37 Lane End Road, Middleton on Sea, Bognor Regis, West Sussex, PO22 6LT

Re: M/42/15/HH - 37 Lane End Road, Middleton-on-Sea

29th May 2015

PROPOSED GROUND FLOOR PLAN 1/50

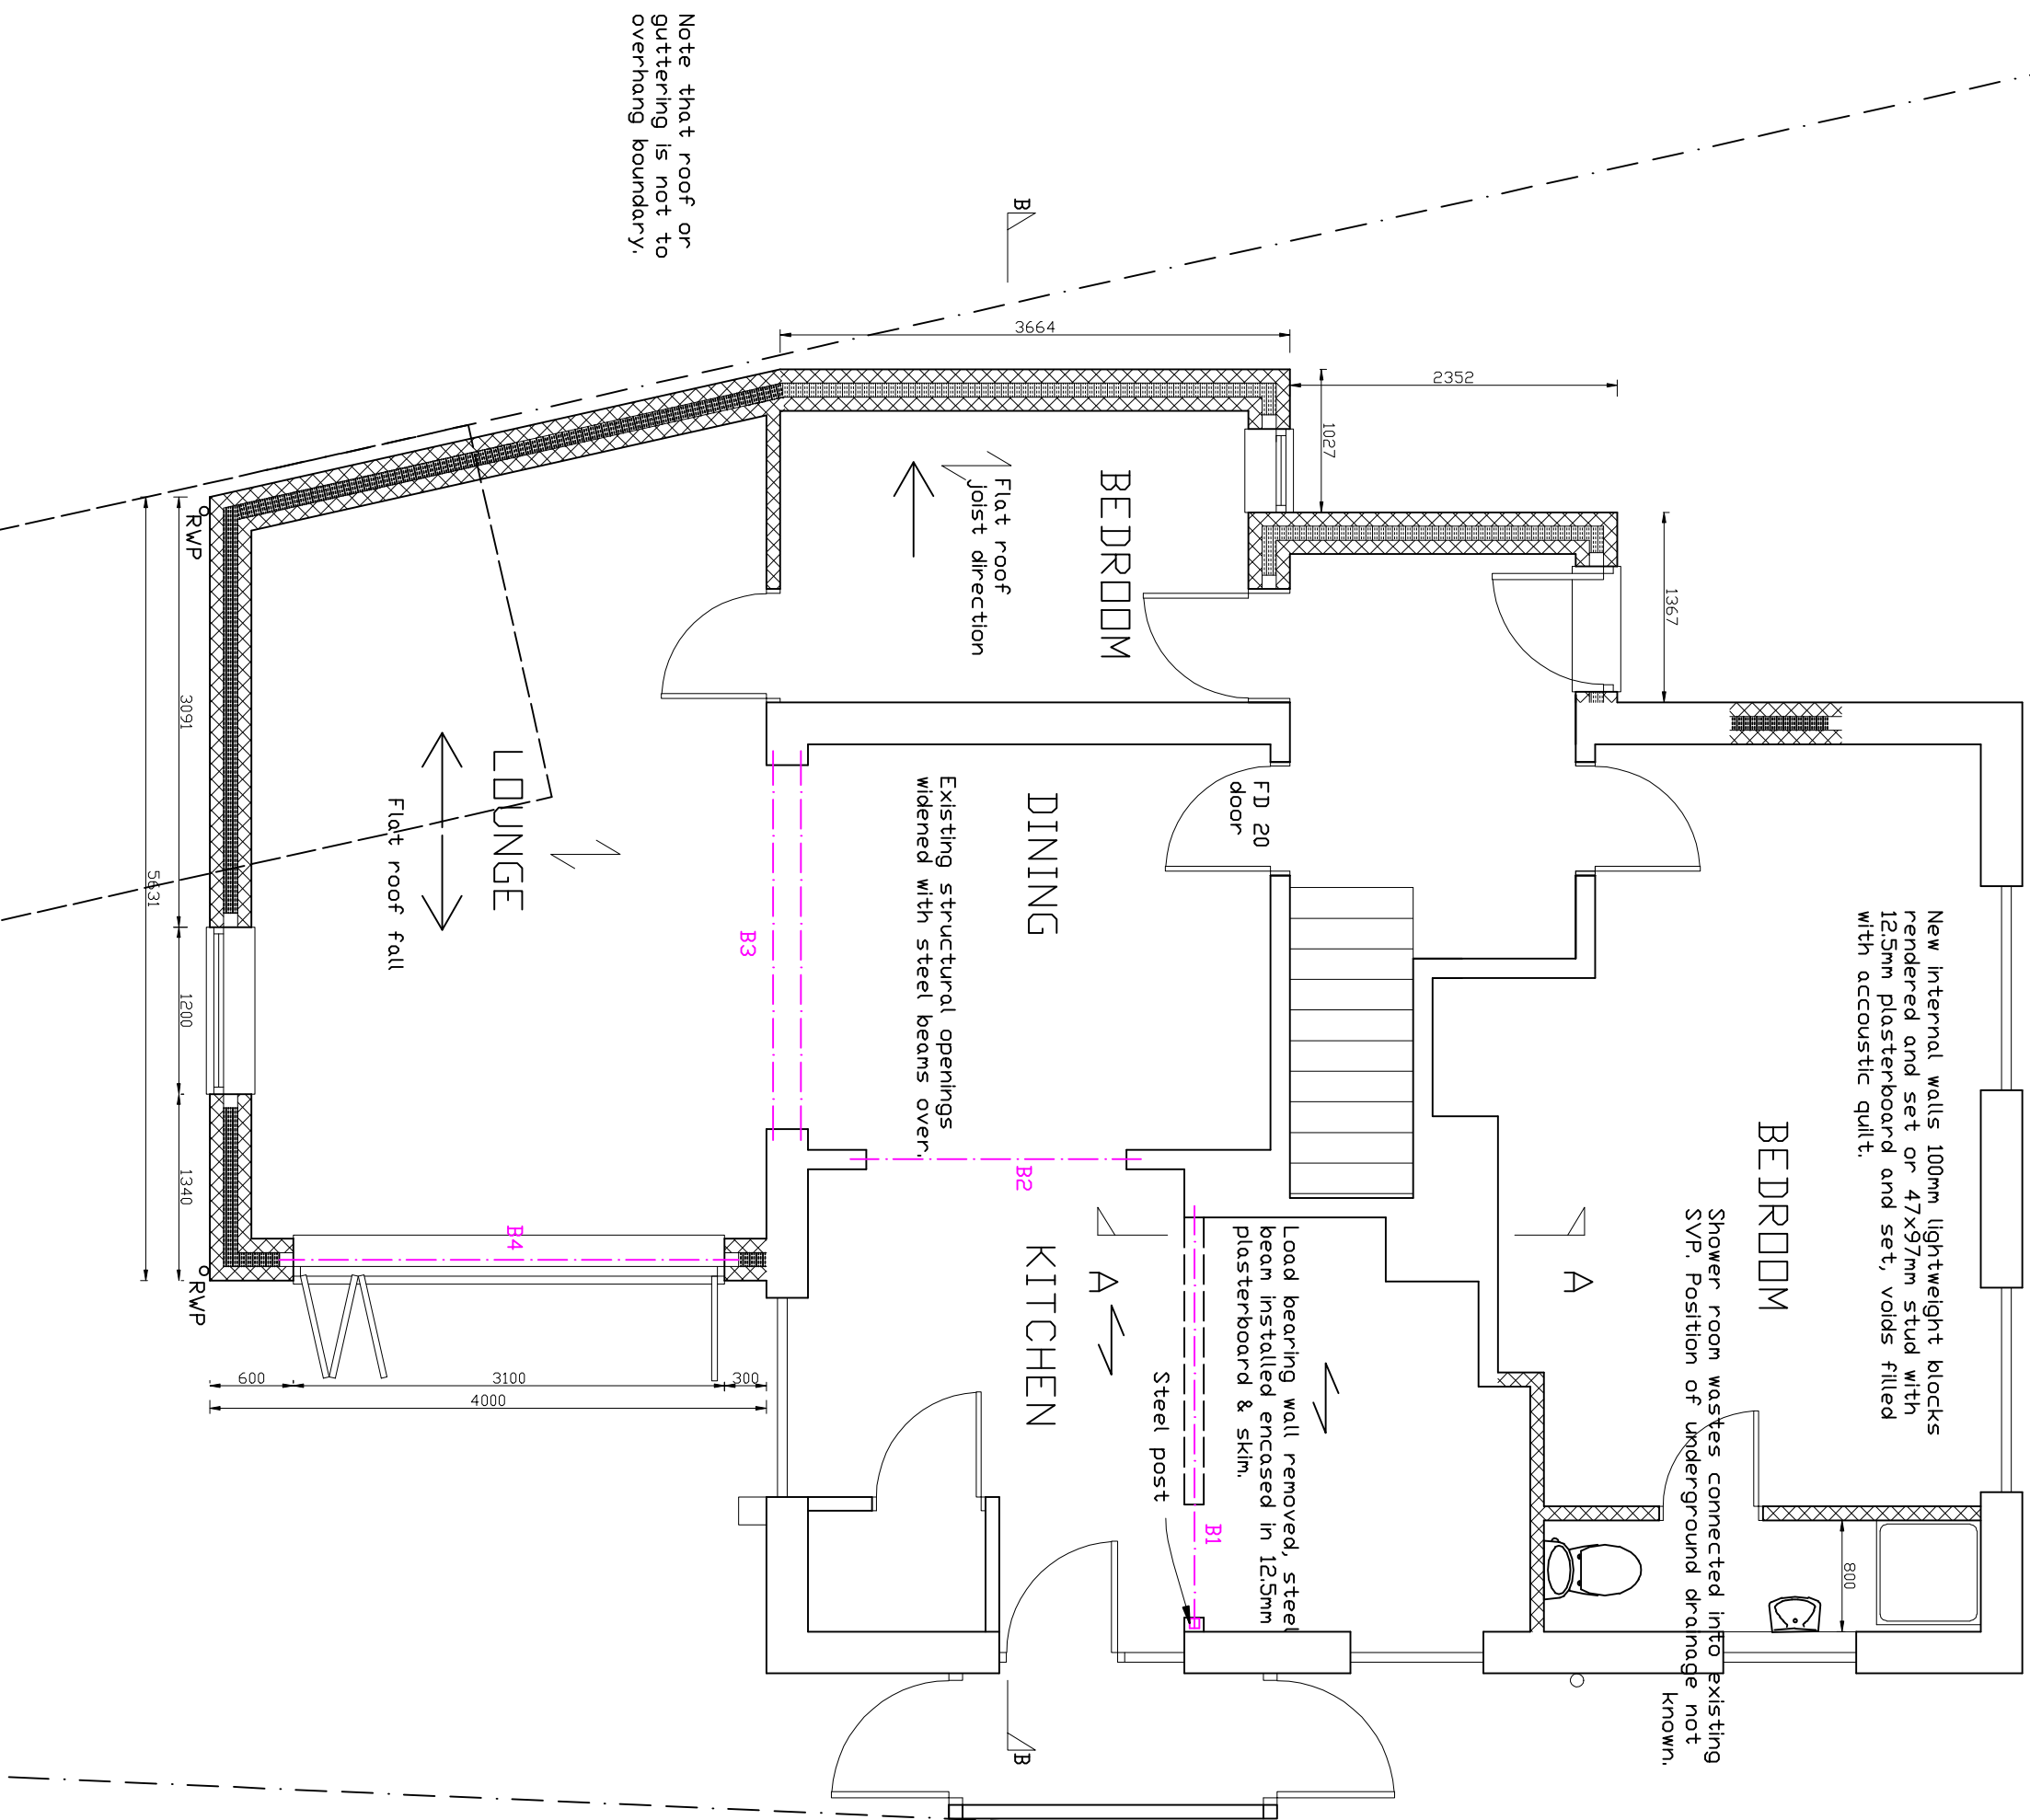
- a) we have reduced the size of the proposed bedroom on the side of the property so instead of the outside wall running parallel to the boundary with our neighbours it now runs away from the boundary meaning as it nears the point where our neighbours front door is located it is now some 1.8m from the left hand side of their door (as you look from the outside) and is not directly in front of the door minimising any impact on light due to the height of the extension.

- b) We have removed from our original plan relocating our garage from its current location to the side of the property. By doing so we remove any extensions along our boundary directly in front of our neighbour front door (with the exception of a small extension 1.3m wide over 2.8m from their front door) or along the boundary impacting light into their front bedroom side window and making a significant reduction in the size and overbearing nature of our proposed extension to remove any significant creation of a passageway effect or impact on light into their front door.
